# WISWELL PARISH COUNCIL

**Planning Application No: 3/2012/0623**

**Outline application with all matters reserved for residential development of 23 dwellings with access, parking and associated landscaping following demolition of no.s 23 and 25 Old Row**

**Land at 23-25 Old Row, Barrow, Clitheroe, Lancashire**

PROPOSED SITE LAYOUT

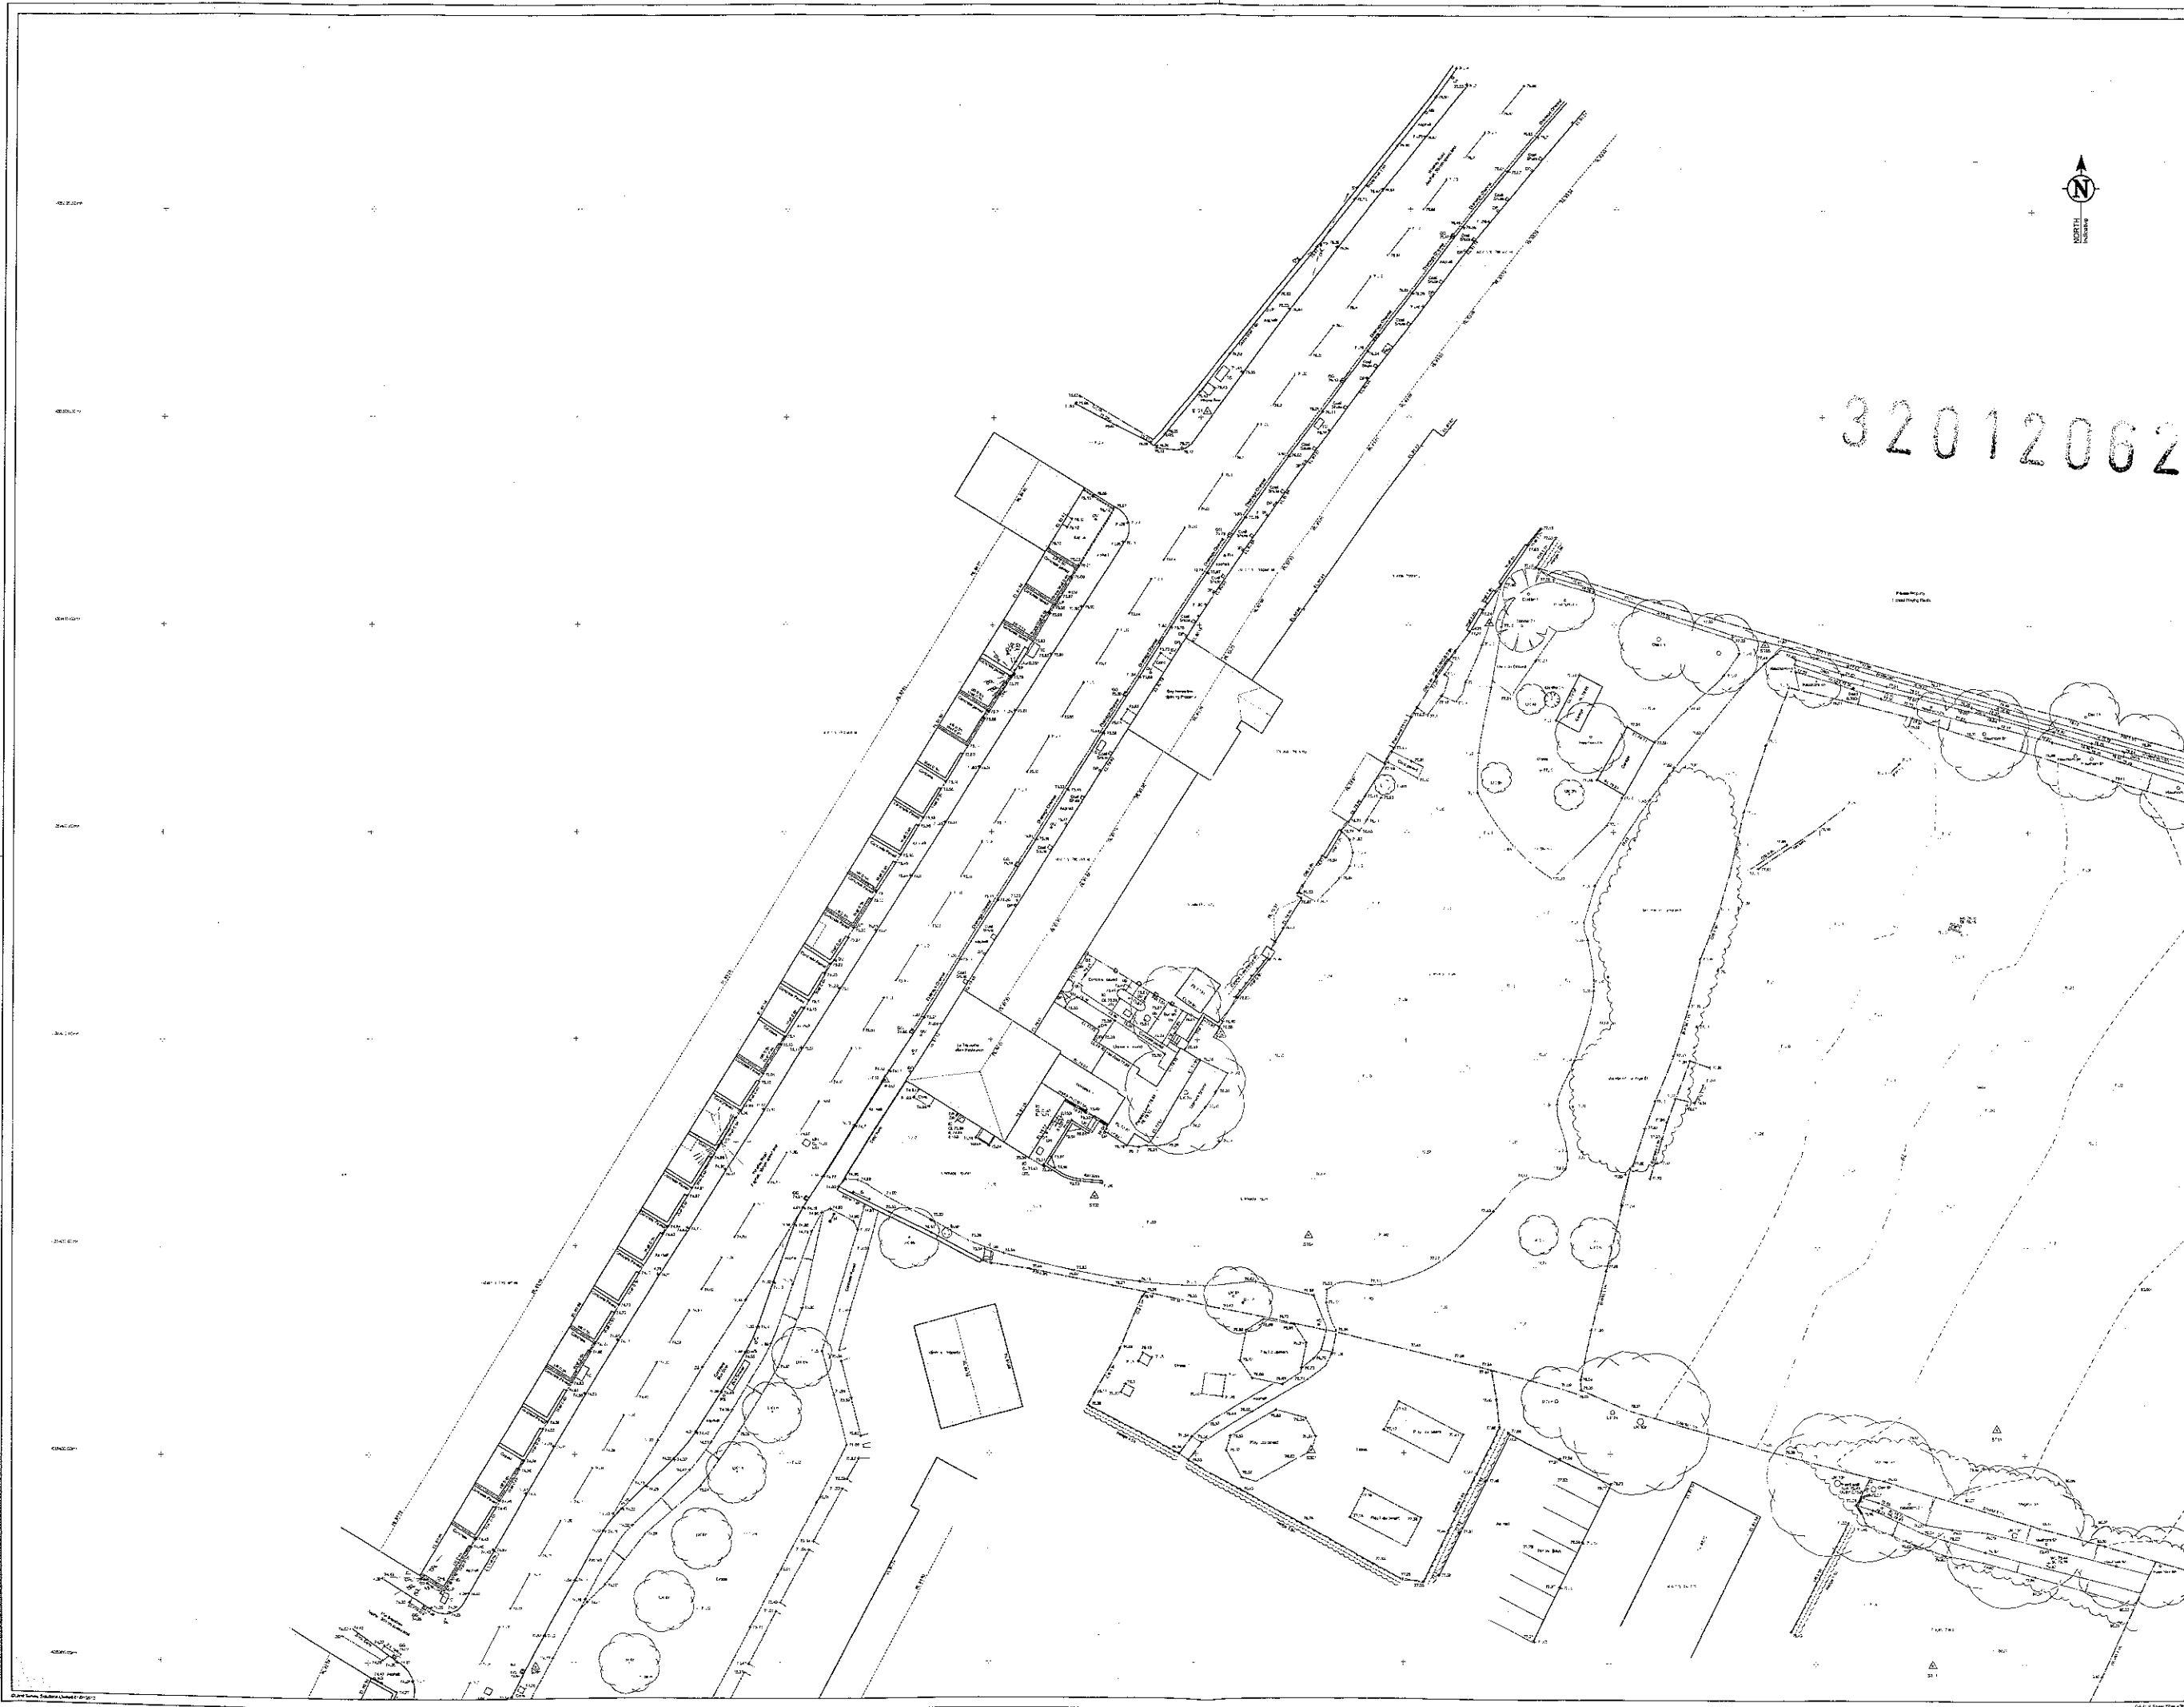
The developers have stated that demolition of 23-25 Old Row is required for access purposes. However, it is noted that replacement dwellings will be erected on the footprint of these buildings and it is unclear exactly how access to the site will be improved.

The Parish Council were very surprised to read that Mr Martin Nugent of ICC had 'no objections to the application on highway safety grounds.' The proposals will have a significant effect on highways in the village and Members believe the safety of road users will be compromised. Removing the existing car park will mean that residents and parents using the local school will have to park on Whalley Road. This causes safety issues as pedestrians have to cross busy roads, negotiate round parked cars (often parked on the pavement to create more space for passing vehicles on the narrow road) and vehicles turning into the new development. Residents fear a return to the overcrowded road conditions which existed before the bypass was built.

Again, the Parish Council requests that this development is accessed via the roundabout on the A59 rather than from Whalley Road? A similar plan was approved for the nearby Barrow Brook development and this has been successful in limiting traffic congestion and ensuring residents' safety.
